re: Geotechnical Review of Site Grading
Proposed School (Block 261) – Quinn’s Pointe – Stage 2
1045 Kilbirnie Drive – Ottawa

date: July 26, 2022

file: PG6364-MEMO.02

Grading Plan Review

TITLE:	GRADING PLAN
SHEET NUMBER:	C03
SHEET #:	3 OF 6
ISSUE:	ISSUED FOR SPA
DATE OF:	2022-04-13
REV #:	0

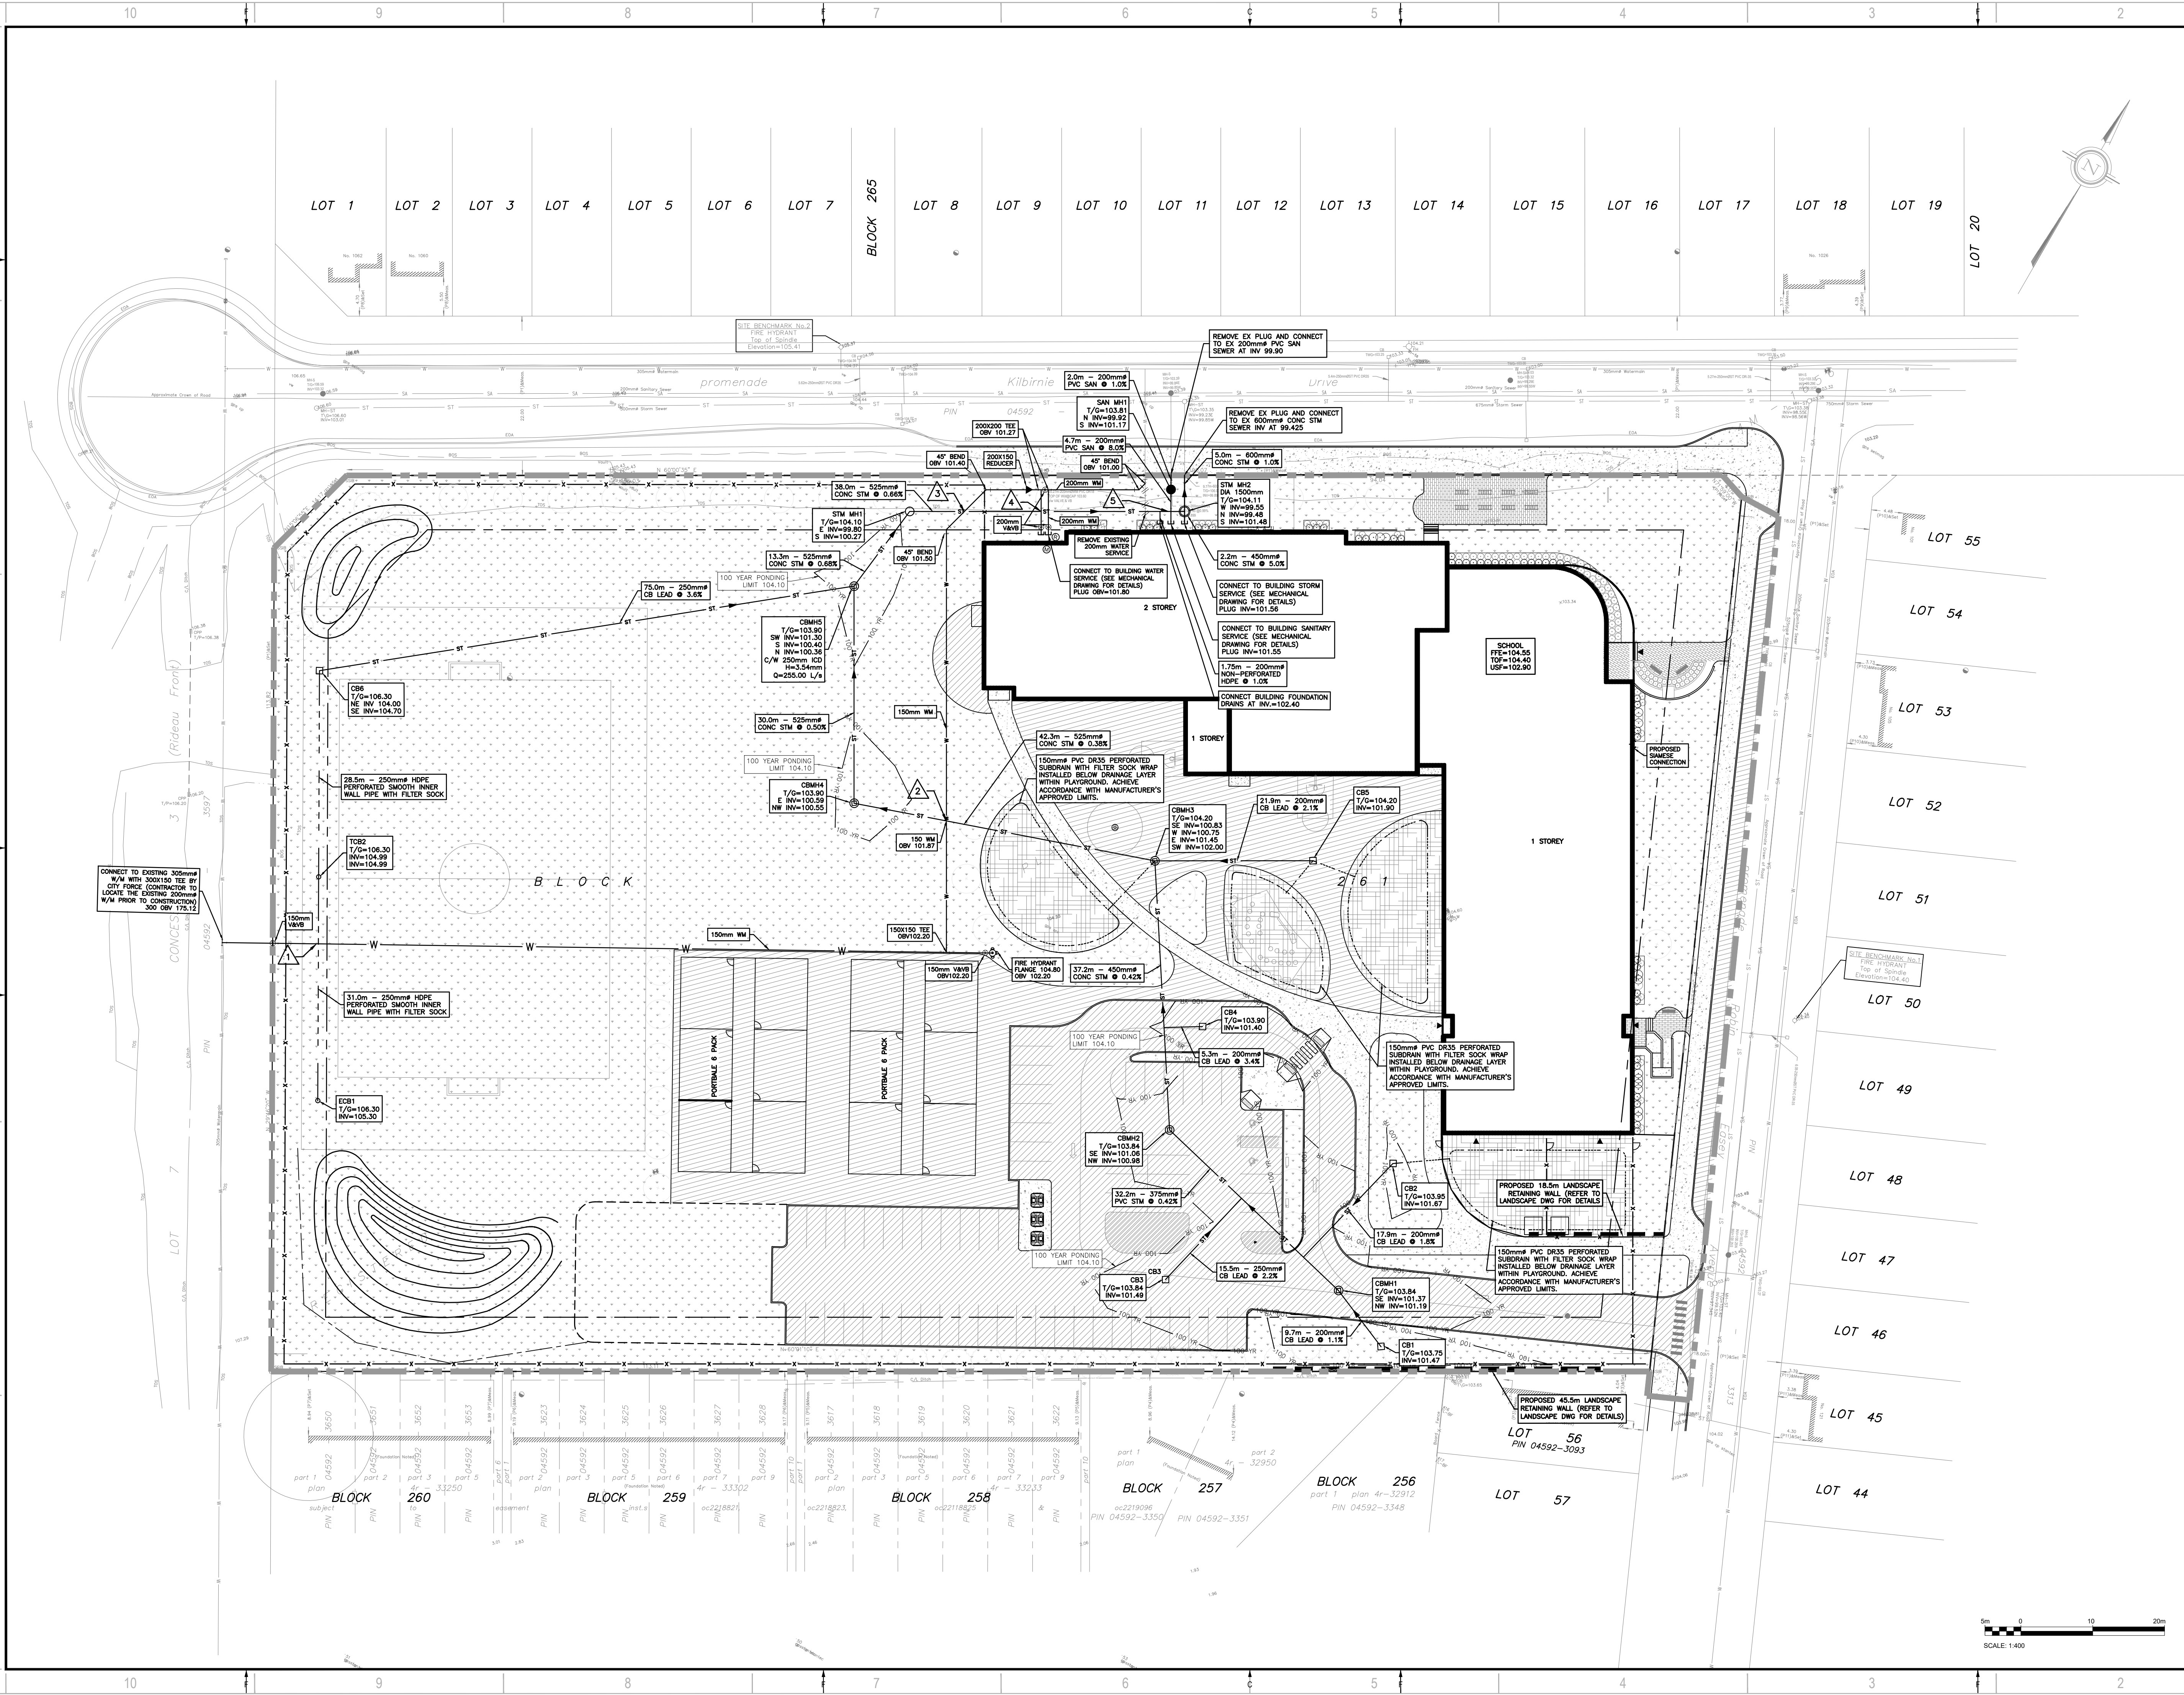
Due to the absence of a sensitive silty clay layer within the subject site, a permissible grade raise is not applicable for the proposed development and the proposed grading is considered acceptable from a geotechnical perspective. Therefore, no lightweight fill is required for the proposed building. Additionally, grading around proposed entryway structures does not exceed the permissible grade raise recommendation. Standard construction practices are considered acceptable.

Based on the current proposed grading, adequate soil cover is available against frost protection for the proposed building foundations. Therefore, rigid insulation will not be required for the proposed foundations from a geotechnical perspective. Furthermore, the grading plan is in general conformance with the recommendations provided by Paterson Group in the aforementioned geotechnical report.
